## Department of Primary Industries

**West Culburra Mixed Use Concept Plan (MP 09\_0088.)  
Response to exhibition of Environmental Assessment**

### West Culburra Mixed Use Concept Plan (MP 09\_0088) Response to exhibition of Environmental Assessment Comment by Fisheries NSW

### **West Culburra Mixed Use Concept Plan (MP 09\_0088) Response to exhibition of Environmental Assessment Comment by NSW Office of Water**

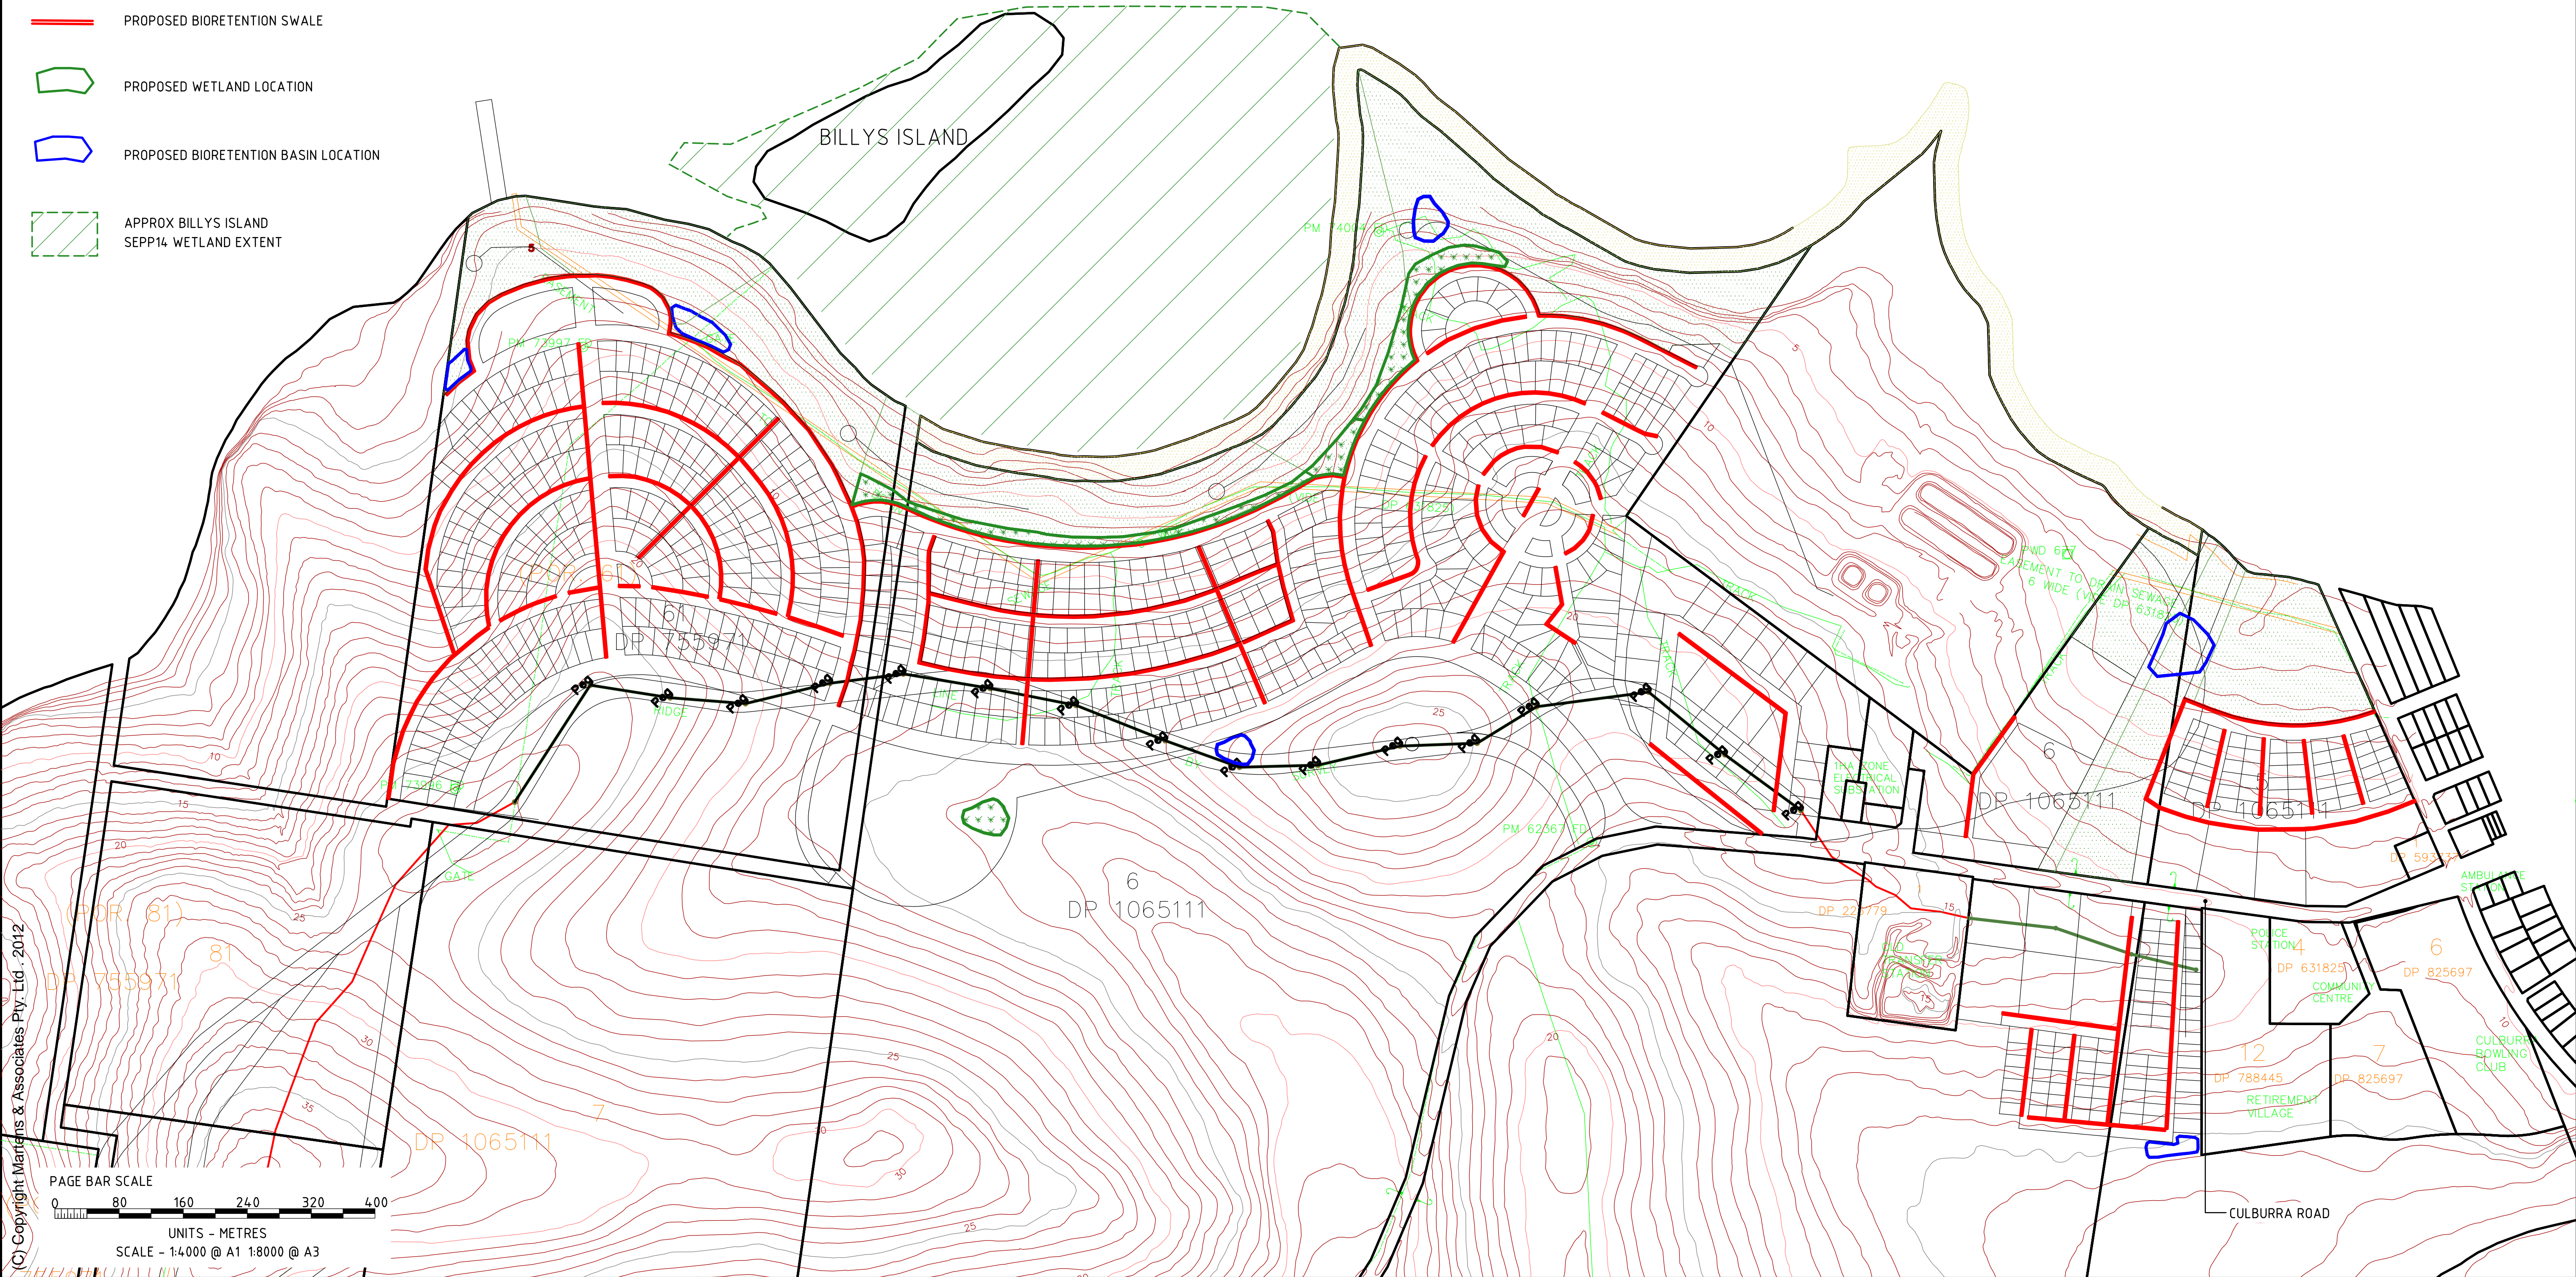
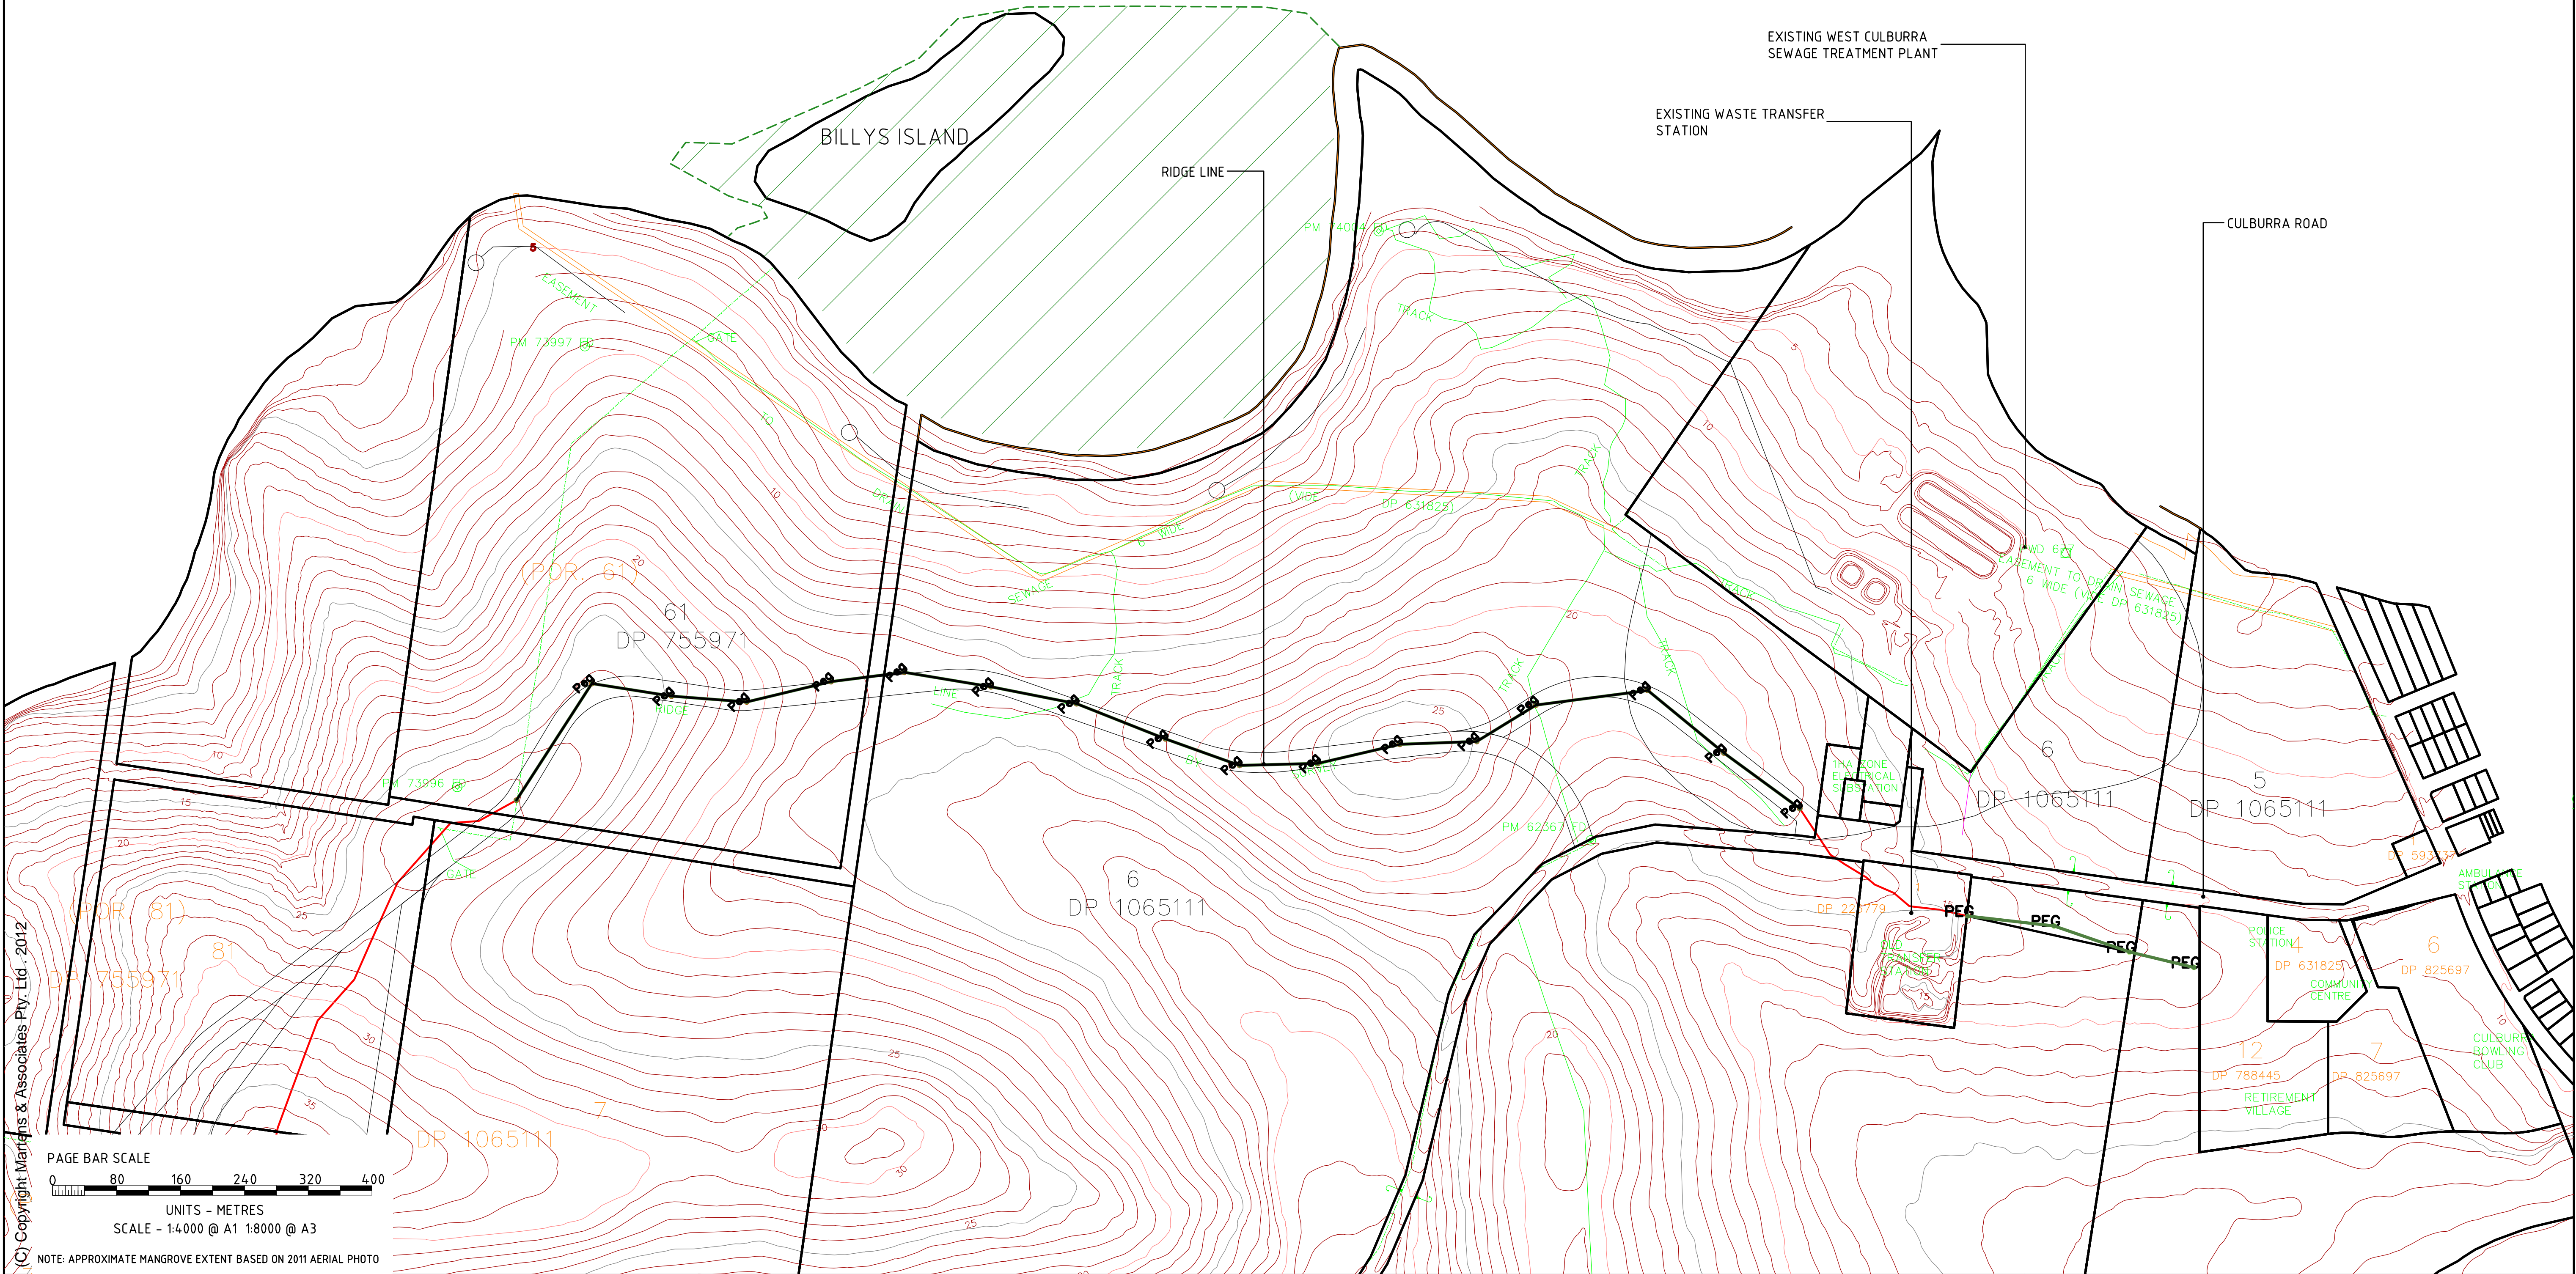
components of the development and subsequently its ability to adequately filter pollutants emanating from the residential subdivision is highly questionable. The Sediment and Erosion Control Plan prepared by Martens and Associates (Appendix P) depicts Earth Diversion Bunds and Sediment Basins located within the buffer zone. The description of the Proposal also highlights the intent to construct a pedestrian/bike path through the buffer and construct various other recreational facilities such as BBQ shelters, picnic tables, fitness equipment etc. There is also a clear intent to clear parts of the buffer right down to the shoreline to create "vistas".

Page 79 of Appendix O suggests that all the APZs, stormwater treatment basins and swales are to be located outside the vegetation setback from the Crookhaven River. This is contradicted by the Sediment & Erosion Control Plan (Appendix P) which clearly shows sediment basins and earth diversion bunds within the foreshore buffer. The Sediment & Erosion Control Plan also shows the earth diversion bund crossing proposed streets and passing through housing allotments which underlines the fact that water quality treatments have not been properly designed.

The proposed buffer will be compromised by a range of ancillary uses including clearing of vegetation beyond the shoreline to create water vistas and some asset protection zones, earthen swales and bio-retention ponds for water quality treatment, in addition to more passive uses such as a pedestrian/bike path and picnic tables.

Water quality control structures for example will require permanent access and ongoing maintenance which will continue to compromise the riparian values and intent of the foreshore buffer zone into the future. Such activities should be located outside of the buffer with the exception of providing stabilised flow paths where necessary, for treated discharge to be safely conveyed through the buffer zone and into the Crookhaven estuary.

NOW supports Fisheries NSW advice that the foreshore buffer zone should be redesigned so as to exclude physical structures such as water quality ponds; excluding wholesale clearing for water vistas and bushfire protection etc from within the designated buffer.
